**From:** [Molly McGuire](#)  
**To:** [Sam.Brick@kpff.com](mailto:Sam.Brick@kpff.com)  
**Cc:** [Ryan Harriman](#); [John Kenney](#); [Jenifer.Clapham@kpff.com](mailto:Jenifer.Clapham@kpff.com); [Kevin Porter](#); [Lewis Chu](#); [Michelle Wahl](#)  
**Subject:** RE: DSR23-006 Riot Games Design Review - Civil Comment  
**Date:** Monday, November 13, 2023 2:48:12 PM  
**Attachments:** [image001.png](#)

**From:** Sam Brick <[Sam.Brick@kpff.com](mailto:Sam.Brick@kpff.com)>  
**Sent:** Wednesday, November 8, 2023 2:51 PM  
**To:** Molly McGuire <[molly.mcguire@mercerisland.gov](mailto:molly.mcguire@mercerisland.gov)>  
**Cc:** Jenifer Clapham <[Jenifer.Clapham@kpff.com](mailto:Jenifer.Clapham@kpff.com)>; Kevin Porter <[Kevin\\_Porter@gensler.com](mailto:Kevin_Porter@gensler.com)>; Lewis Chu <[Lewis\\_Chu@gensler.com](mailto:Lewis_Chu@gensler.com)>; Michelle Wahl <[Michelle@brumbaugh-assoc.com](mailto:Michelle@brumbaugh-assoc.com)>  
**Subject:** DSR23-006 Riot Games Design Review - Civil Comment

I am the civil designer at the Riot project located at 3003 77<sup>th</sup> Ave SE. We received the following comment on the most recent round of city review:

C2.10

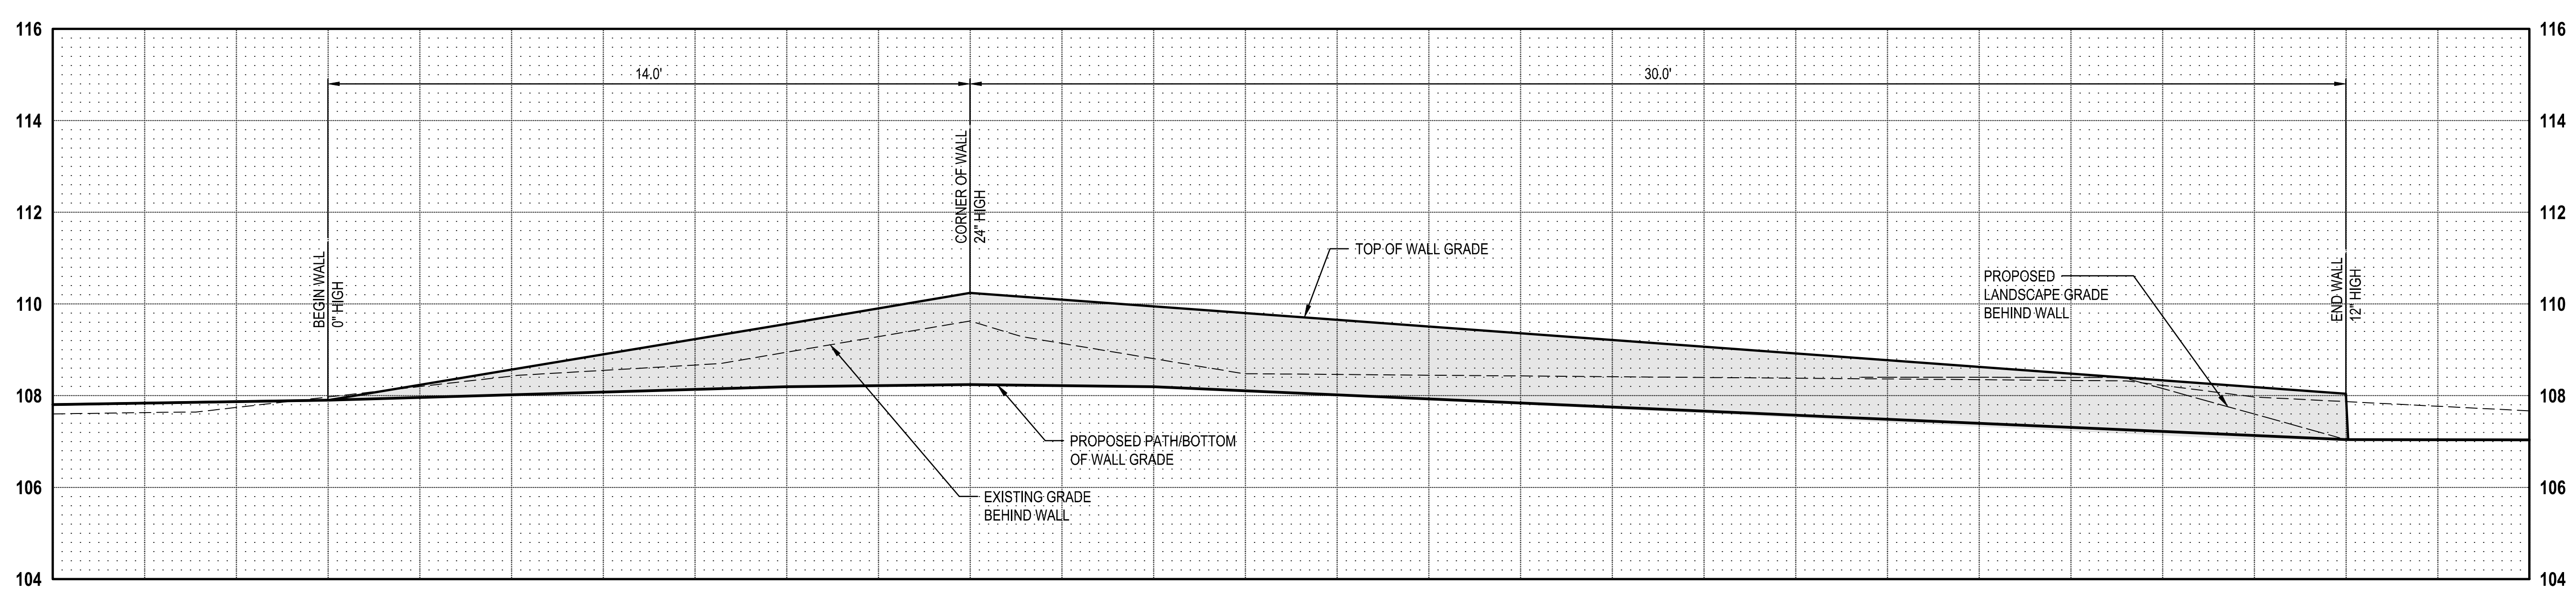
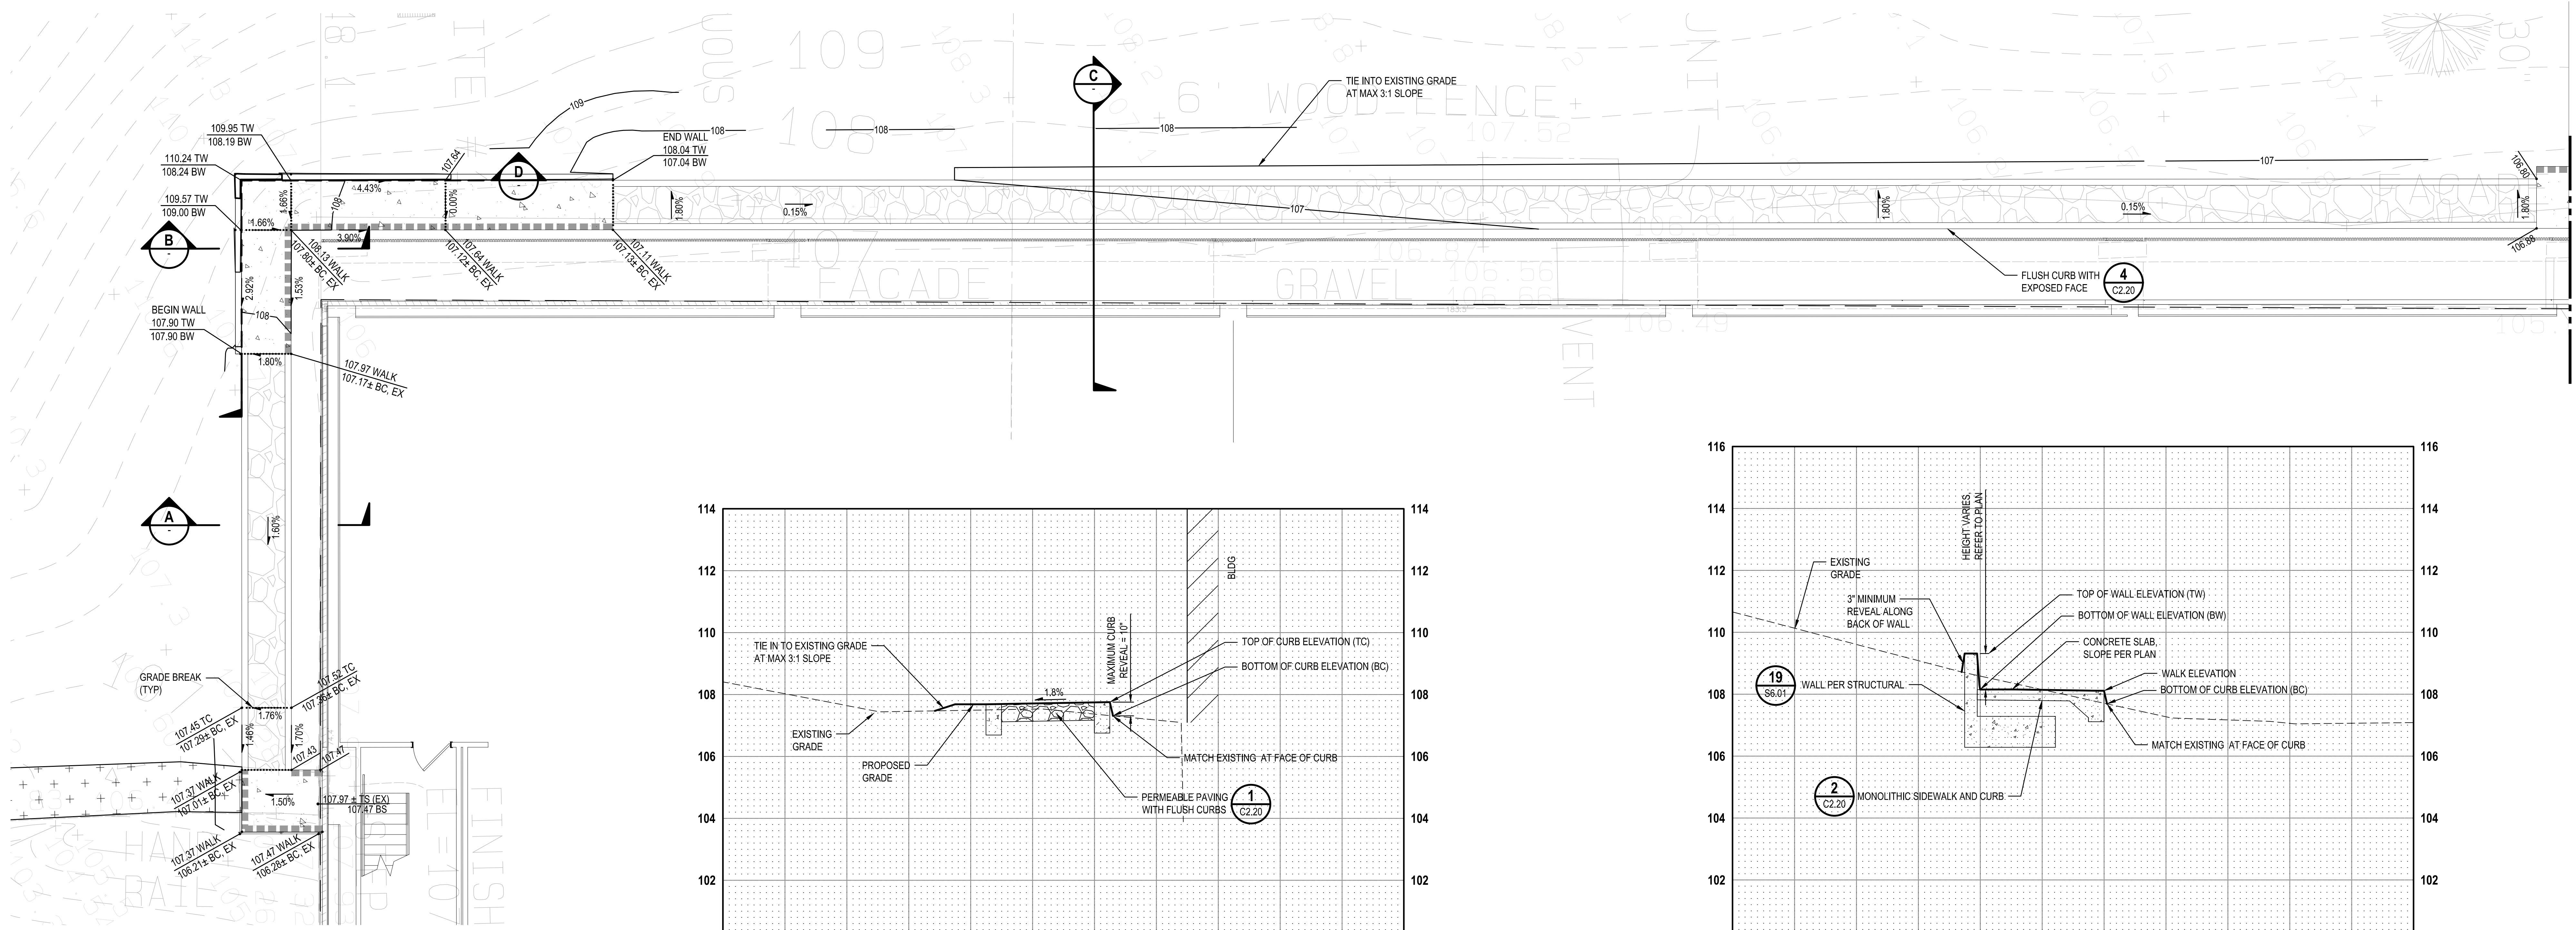
*“Remove grading note within park property on C2.10, as called out in the arborist memo.”*

The intention of this note is to feather into existing grade. The existing grade cannot be met at the property line without resulting in a large slope (~10%) in the landing at the bottom of the stairs. The design proposes only 0.06-CY of fill within the right-of-way and does not propose any cut. We have coordinated with the project's landscape architect (CC'ed on this email) and do not anticipate that this feathering will negatively impact the trees in the right-of-way.

Your solution below would be acceptable to satisfy the comment regarding the removal of the grading note within park property.

To make the intention clearer, we could change the note to read "feather mulch to meet existing grade and match existing condition." We will also add a note, per your comment, specifying that no excavation, grading, or pruning is approved within the right-of-way. Would this solution be acceptable from the city's perspective?
